Application Reference Number:	2026/0107		
Application Type:	Householder		
Proposal Description:	Erection of detached double garage		
Location:	30A Fearn House Crescent, Hoyland, Barnsley, S74 0BA		
Applicant:	Mr Neil Whitlam		
Third-party representations:	None	Parish:	None
		Ward:	Rockingham

This planning application seeks householder planning permission for the erection of detached double garage. A previous application for a double garage 2023/0906 was refused at the same site.

Summer Solstice 9AM

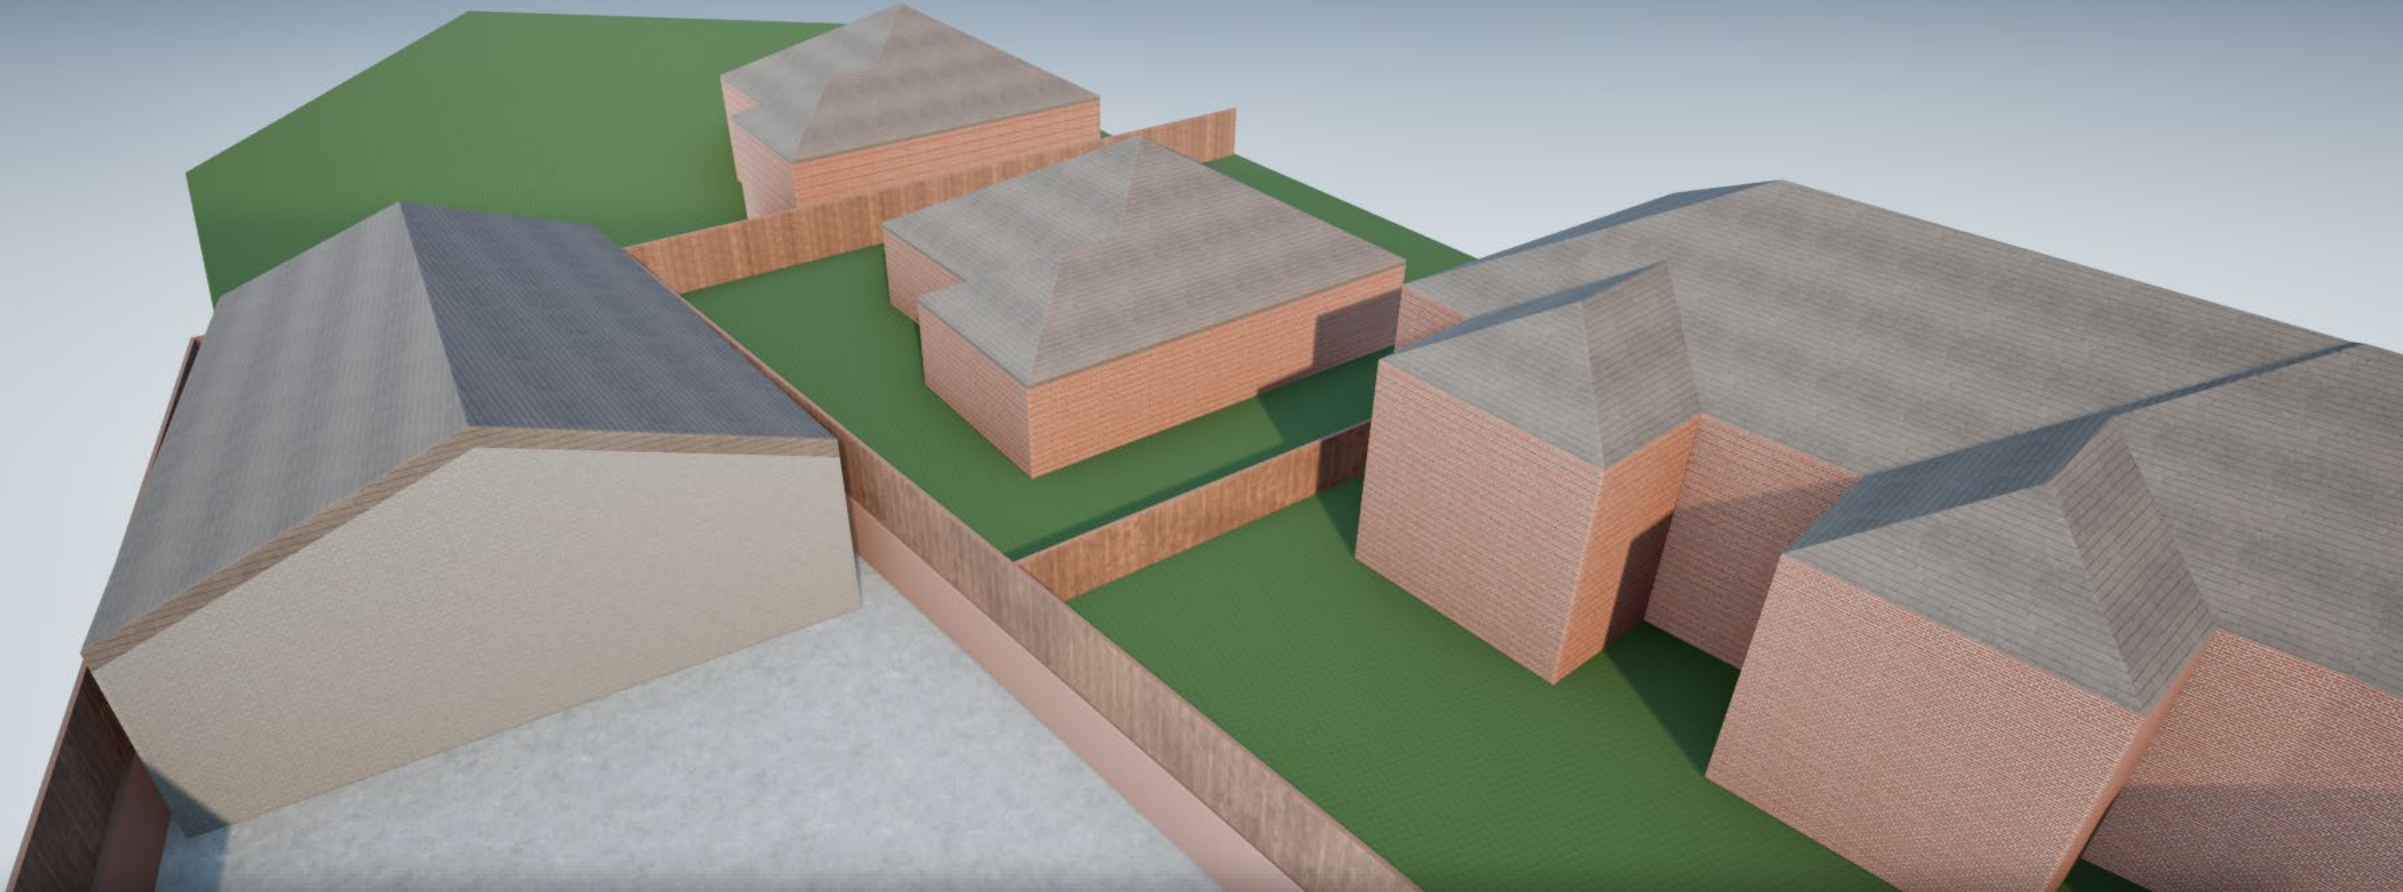
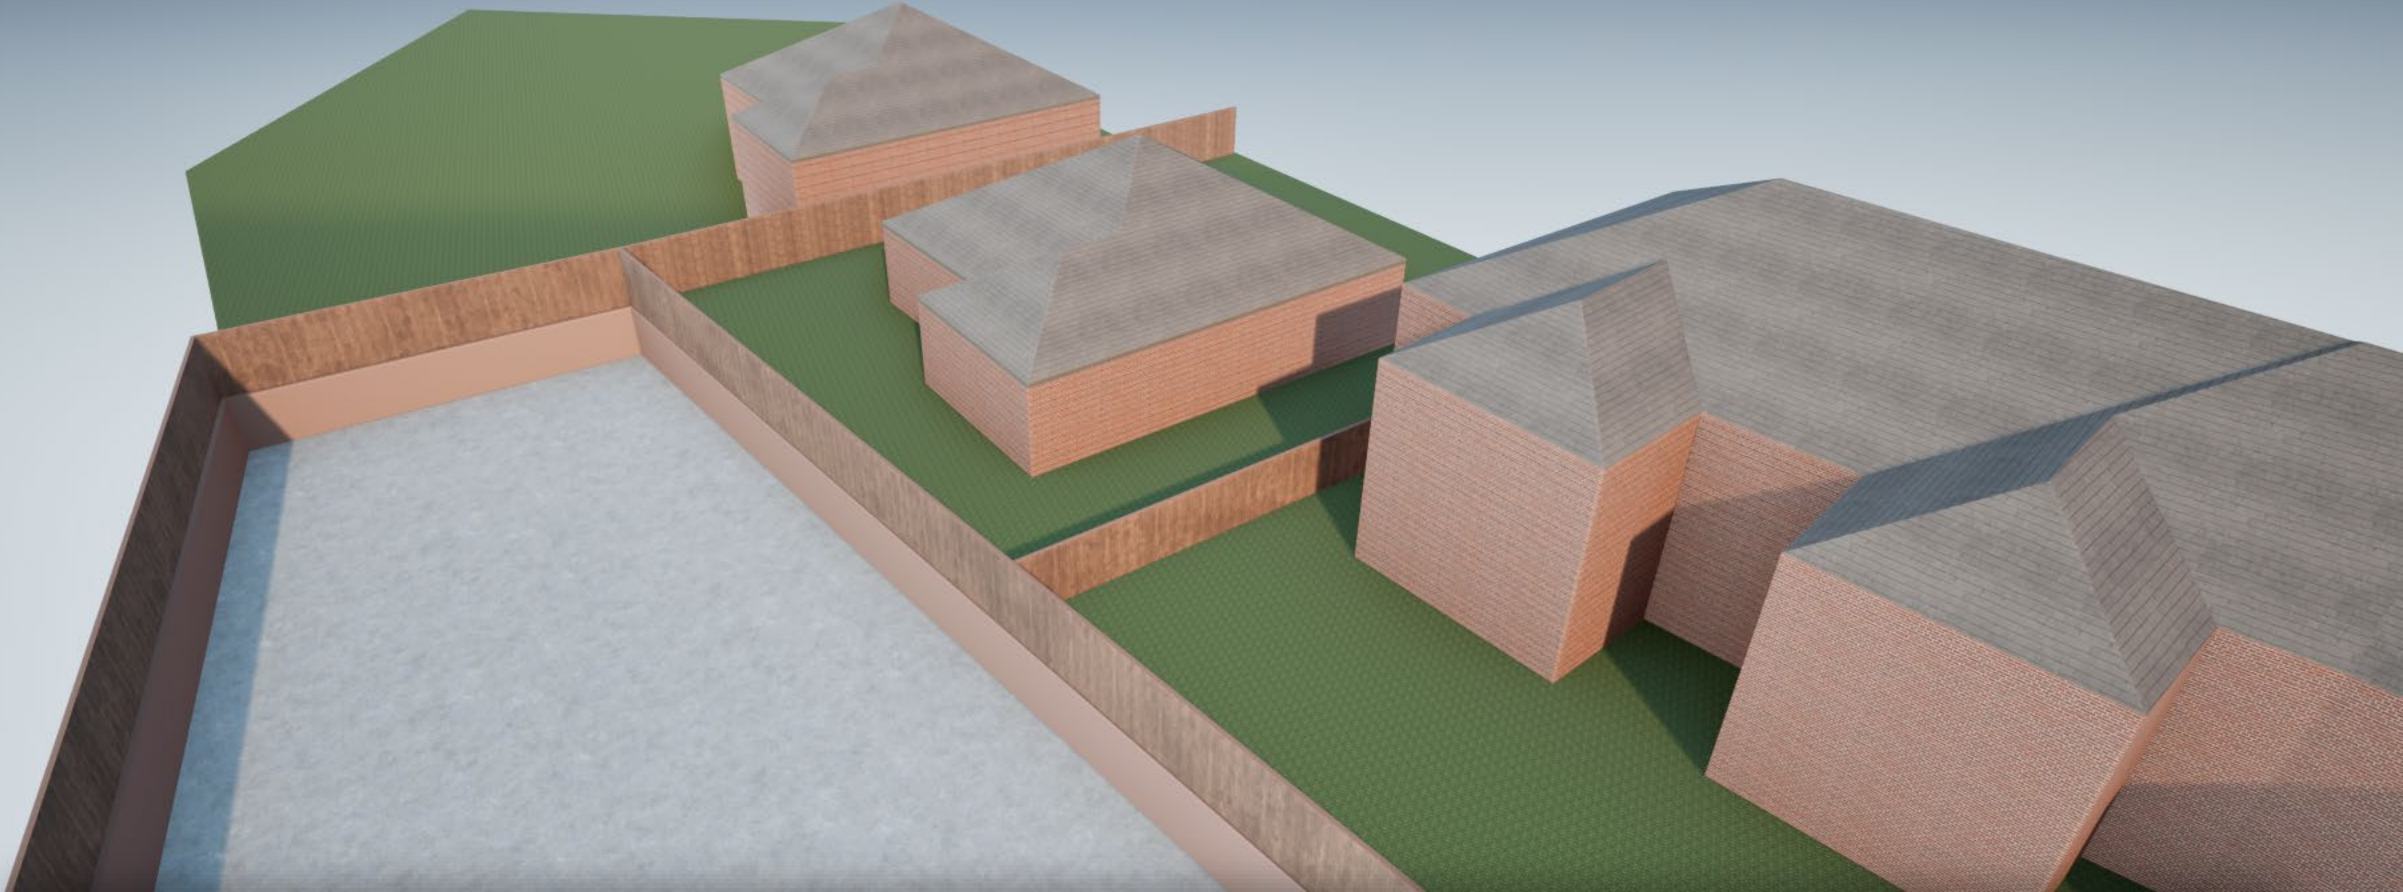
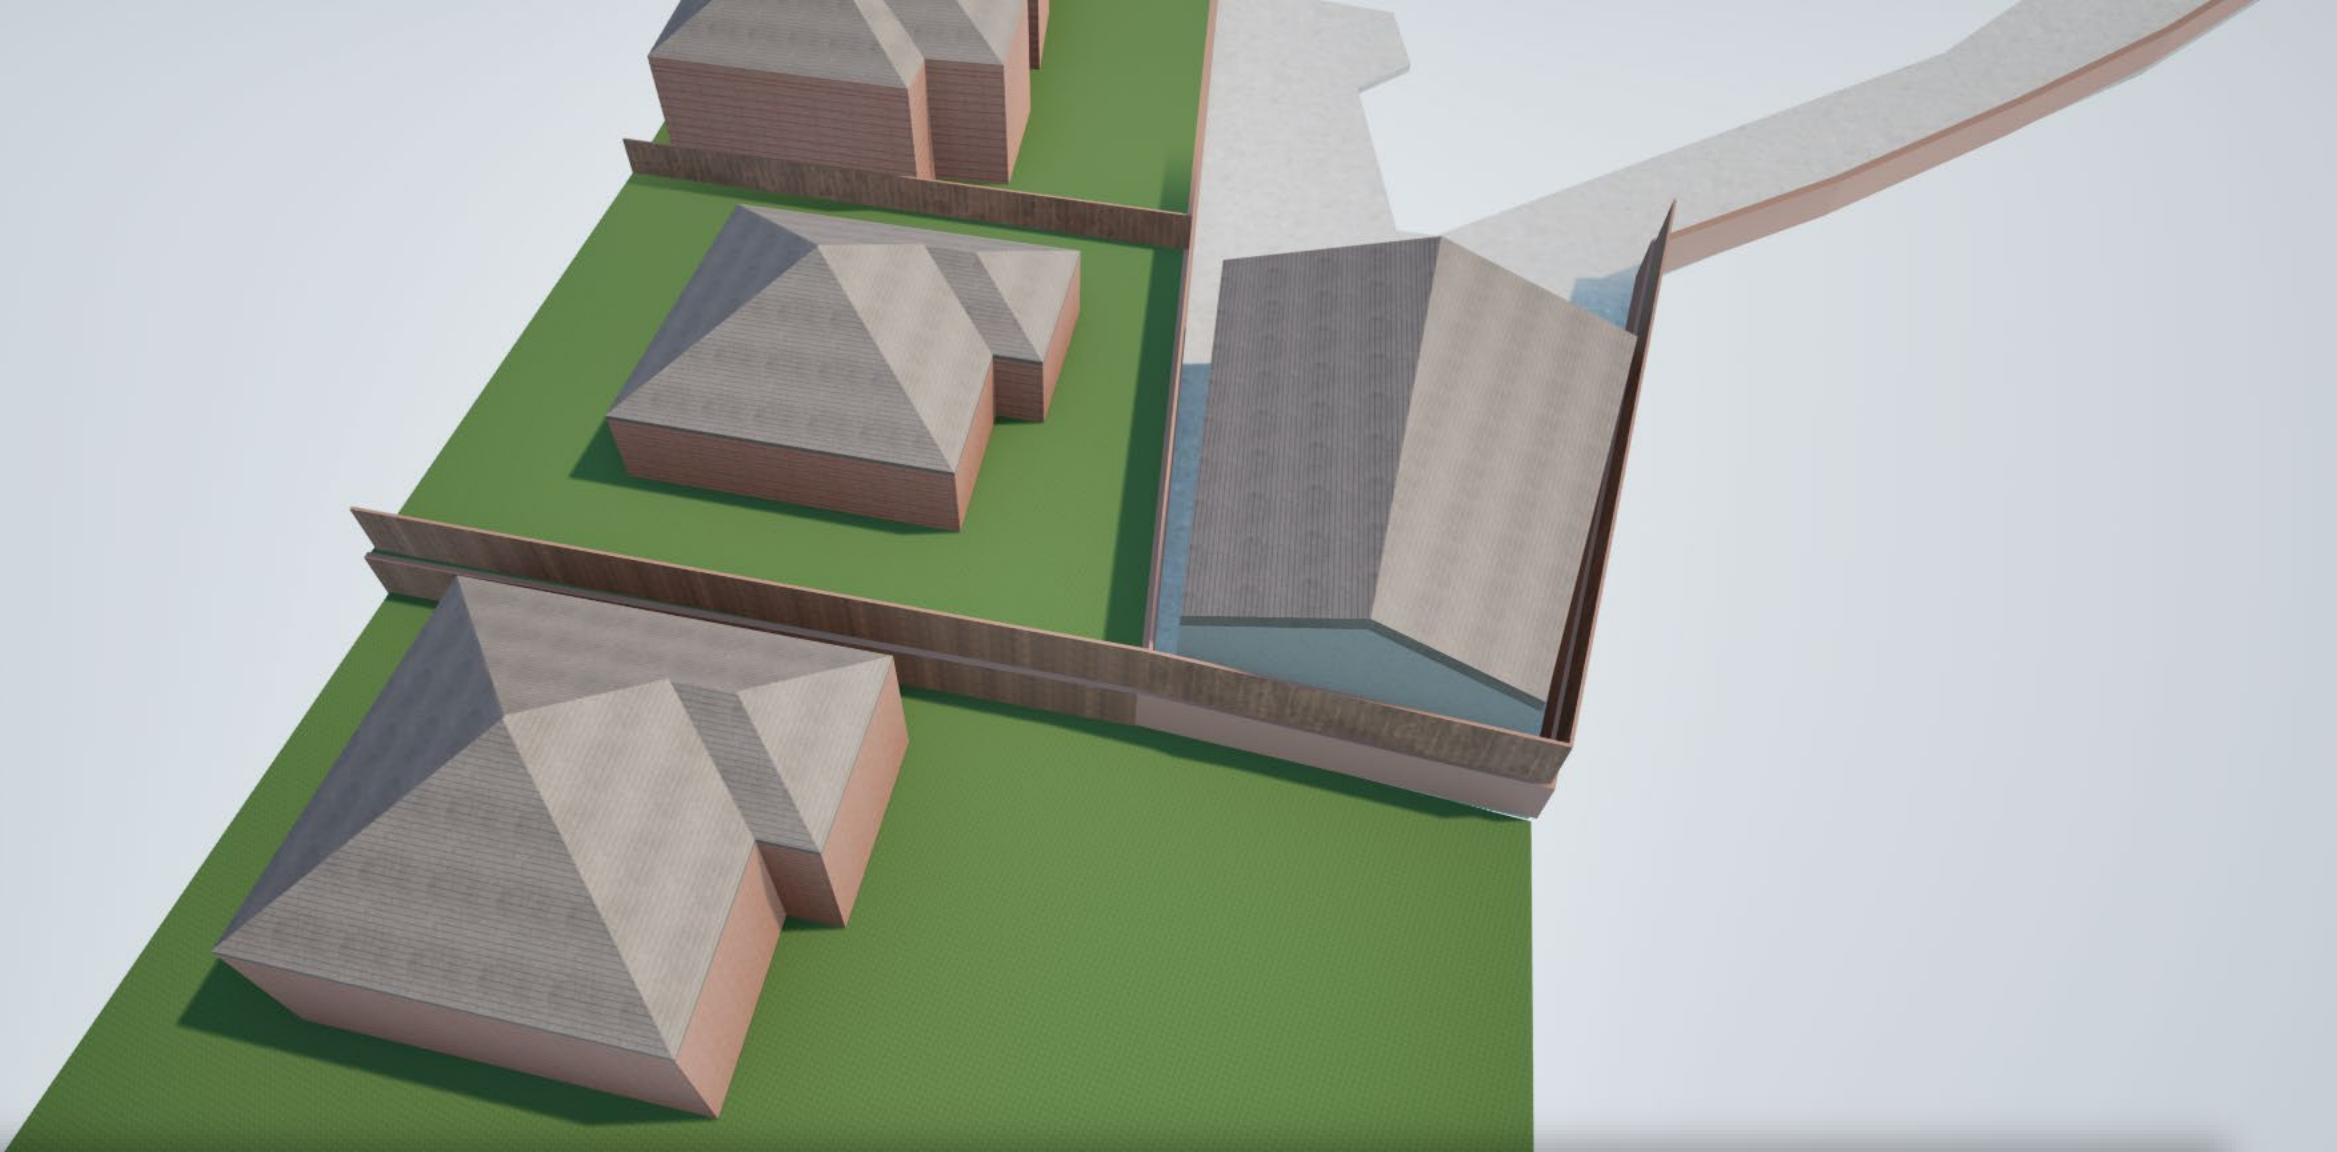
It is noted that the applicant has provided a shadow impact report and analysis which shows the potential impact of shadows created by the proposed garage. The report deems the impact to be negligible and that there will be no adverse impact upon neighbouring properties. The LPA disagrees with this assessment. The analysis also shows the size of the proposed garage in relation to the neighbouring properties further underling the point regarding the excessive size and scale.

It is therefore still deemed that the proposed garage would cause a significant overshadowing of 282A West Street, its rear habitable room windows and its rear garden area. As such the proposal is not in compliance with Local Plan Policy D1 in that it is of poor design and would also be in conflict
